Rezoning Transportation Analysis

Petition Number: 2020-088

General Location Identifier: Tax ID 02932106A

Date	Description
07-23-2020	First Review
09-22-2020	Second Review
10-19-2020	Third Review
11-30-2020	Fourth Review

OPTION 1A: PROSPERITY RIDGE ROAD EXTENSION SECTION WITH BICYCLE LANES (SHOWN WITH ON STREET PARKING WHERE APPLICABLE)

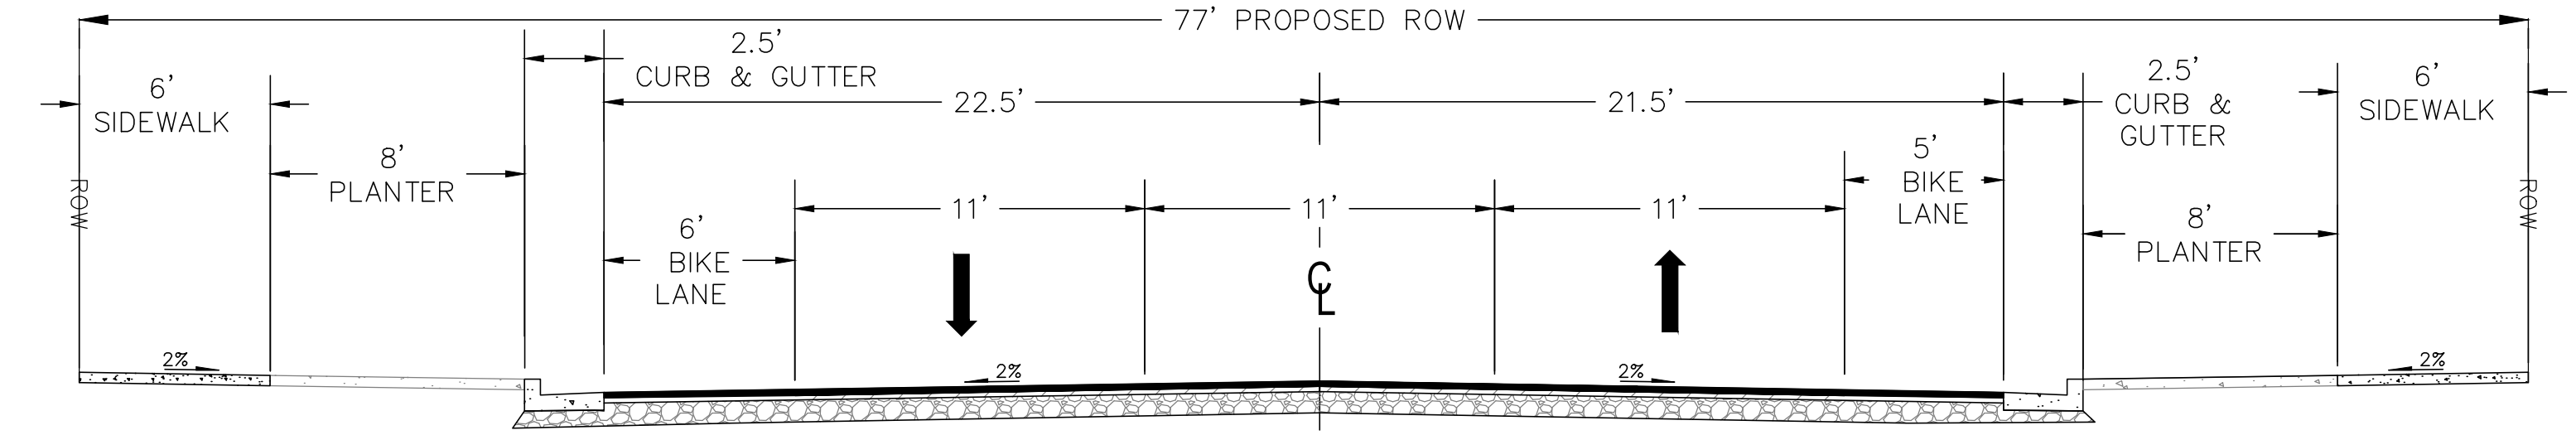
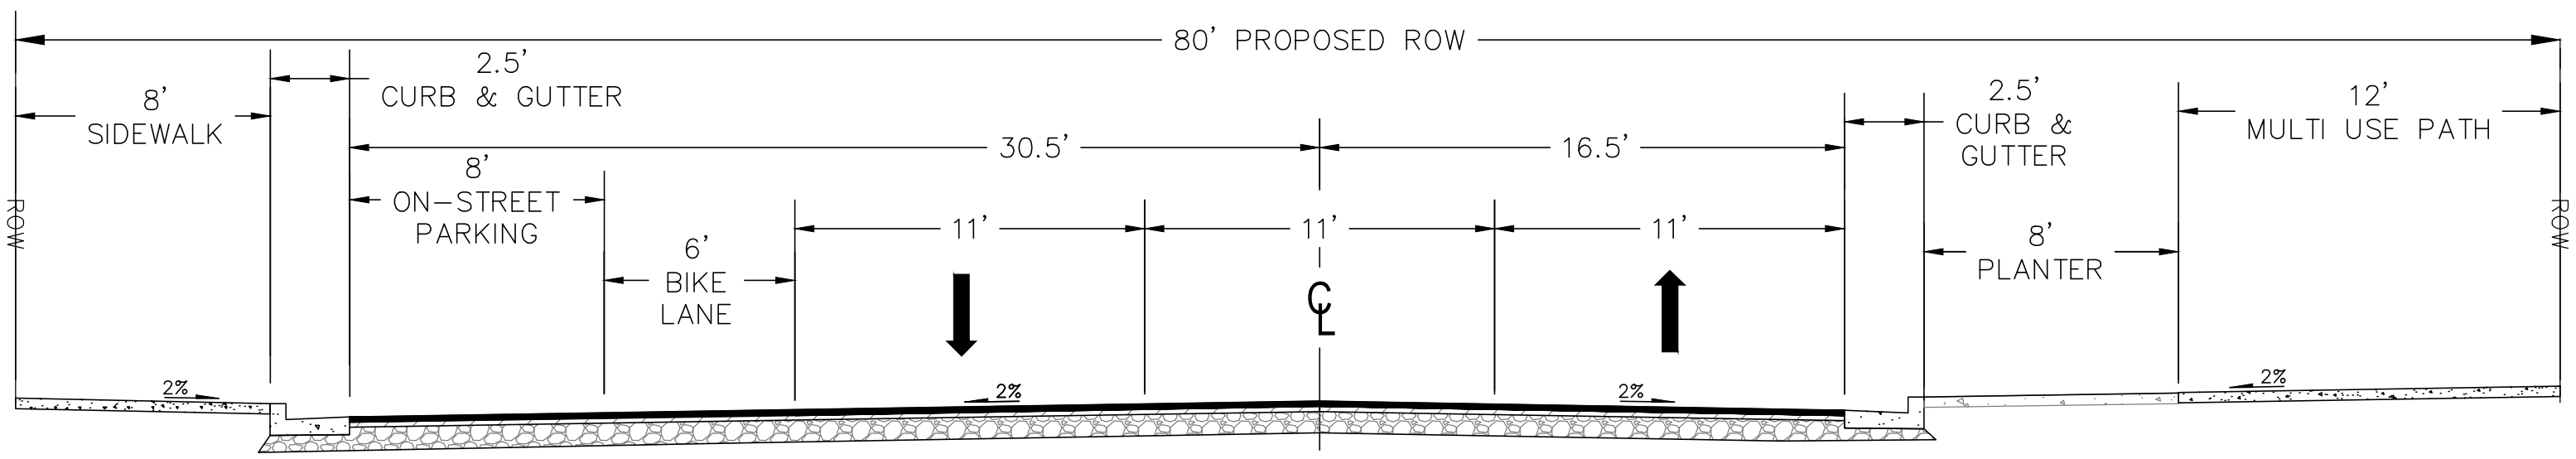
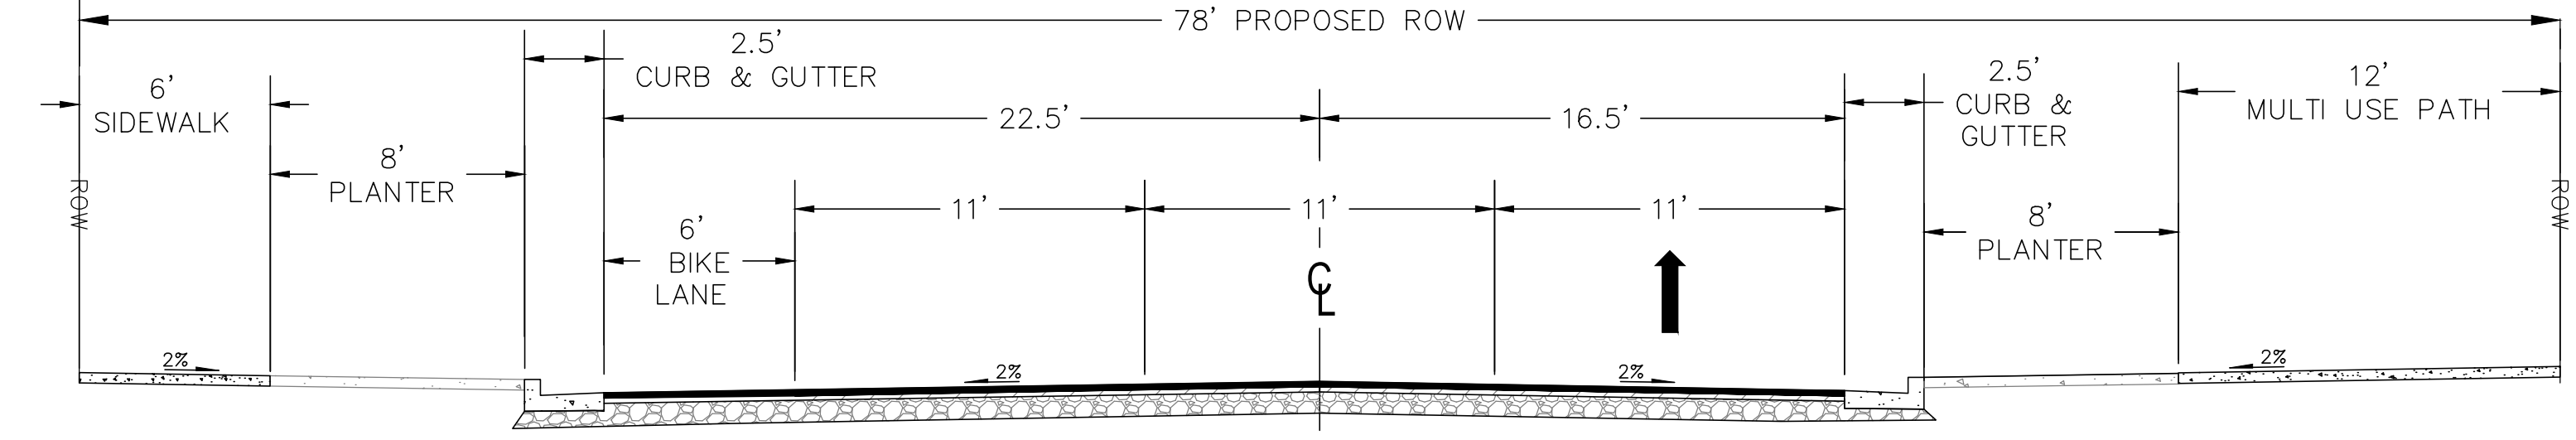
5. ~~The petitioner should revise the site plan and conditional note(s) to clarify which USDG street sections are proposed on each internal street.~~
6. ~~The petitioner should revise the site plan and conditional notes (Section 3.C. and 5.D.) to include either a planting strip or amenity zone adjacent to on-street parking, in conformance with the Prosperity Hucks Area Plan cross sections.~~
7. **Outstanding** Increase the width of the bike lanes to 5 ft, in accordance with Charlotte BIKES. The petitioner should revise the site plan and conditional note(s) to revise the Prosperity Ride Road Extension to replace the proposed 4-foot bike lane with a 5-foot bike lane. Please revise the proposed valley gutter shown to a 2.5-foot curb and gutter.

8. **Outstanding** Revise the site plan and conditional note(s) to include the recommended improvements, as included within the TIS.
9. **Outstanding** Revise the site plan and conditional note (Section 3.E.) specifying all transportation improvements will be approved and constructed before the site's first building certificate of occupancy is issued. Alternatively, the petitioner may phase transportation improvements if said improvements and phasing are explicitly described in site plan notes or as listed within the approved TIS.
10. **New comment (site plan dated 10-14-2020):** The petitioner should revise the updated Prosperity Ridge Road Extension cross section to include two separate cross sections with and without on-street parking. The proposed typical cross section places the curb and gutter at the incorrect location, if on-street parking is provided.
